9 August 2019

File No: SSD-9726
Our Ref: R/2018/32/A

SSD 9726 - Adaptive Reuse of the Royal Hall of Industries, 1 Driver Avenue, Moore Park.

Figure 5 Proposed stormwater works

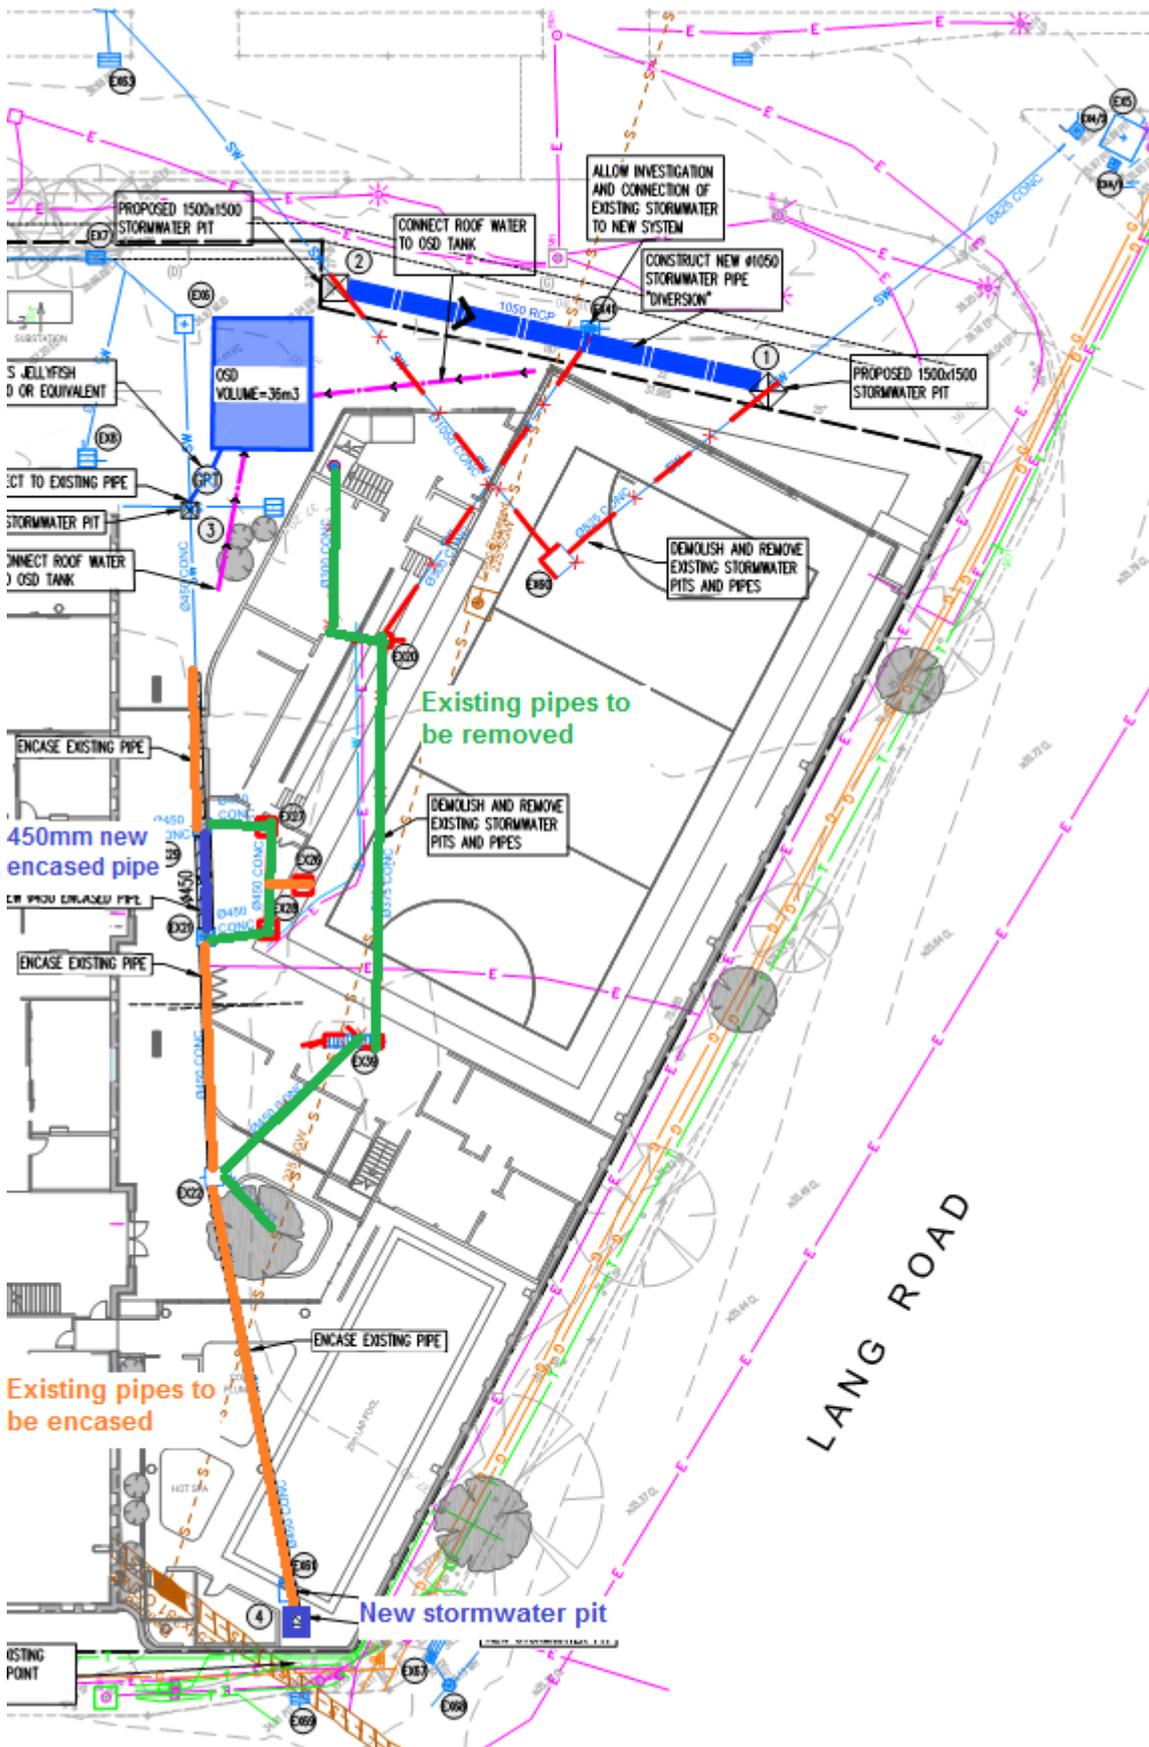
- A MUSIC-Link report (Model for Urban Stormwater Improvement Conceptualisation) be submitted to demonstrate compliance with the water quality requirements.

Figure 27 | Proposed and alternative crossover location shown in relation to the EQ car park access (Base source: Nearmap)

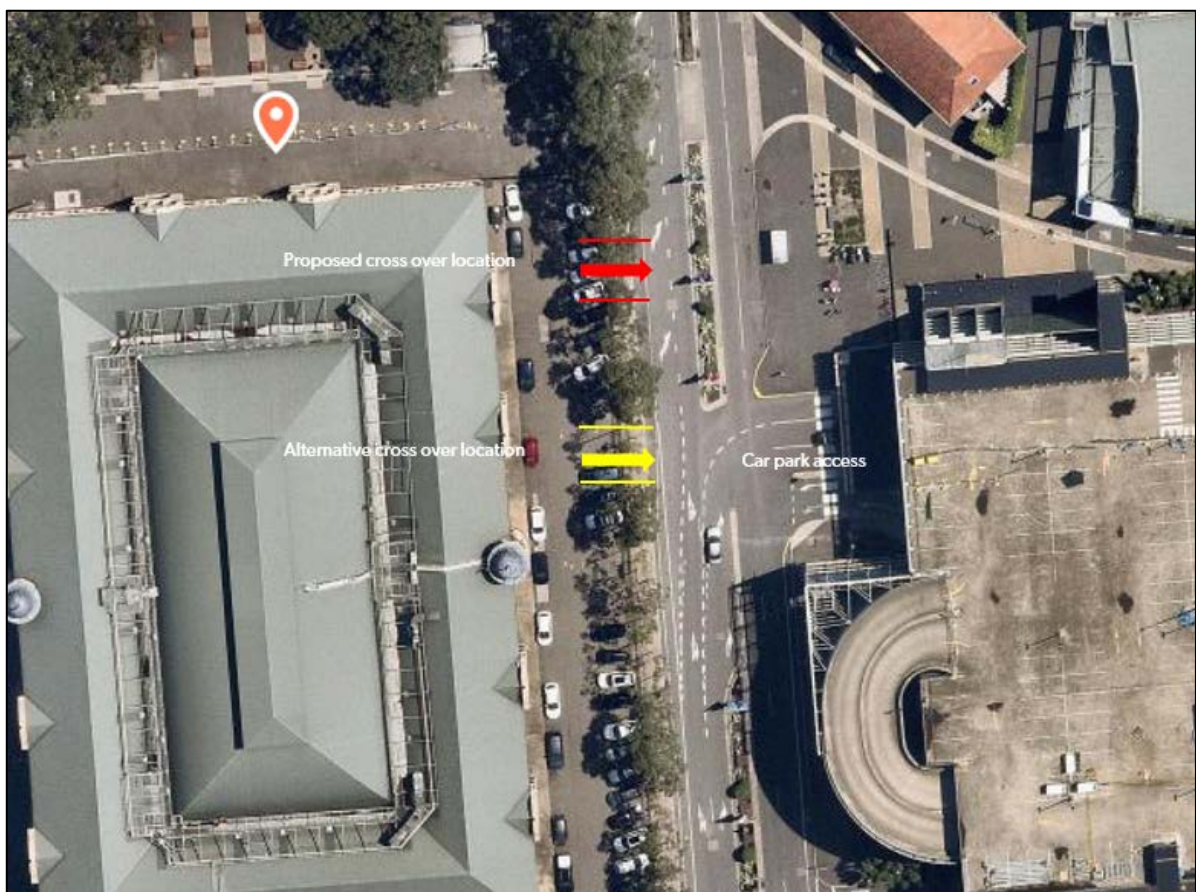
The marking of the trees is not to scale or indicative of the existing tree size and canopies. The trees proposed for removal on the northern side are the largest and healthiest trees within the group planting. Due to the lack of detail in the

plans of the proposed driveway crossovers, it is likely that more than 6 trees will be removed. The exact impact on the trees is difficult to determine as the provided information was limited. The trees, identified as trees 10-79 on Errol Flynn Boulevard have been planted closely together as a linear verge planting and it is most likely that the group of trees will have interconnecting root systems. Cutting into the verge for the proposed driveway crossover will have an adverse effect on the neighbouring trees as it will be difficult to determine which roots belong to the which tree.
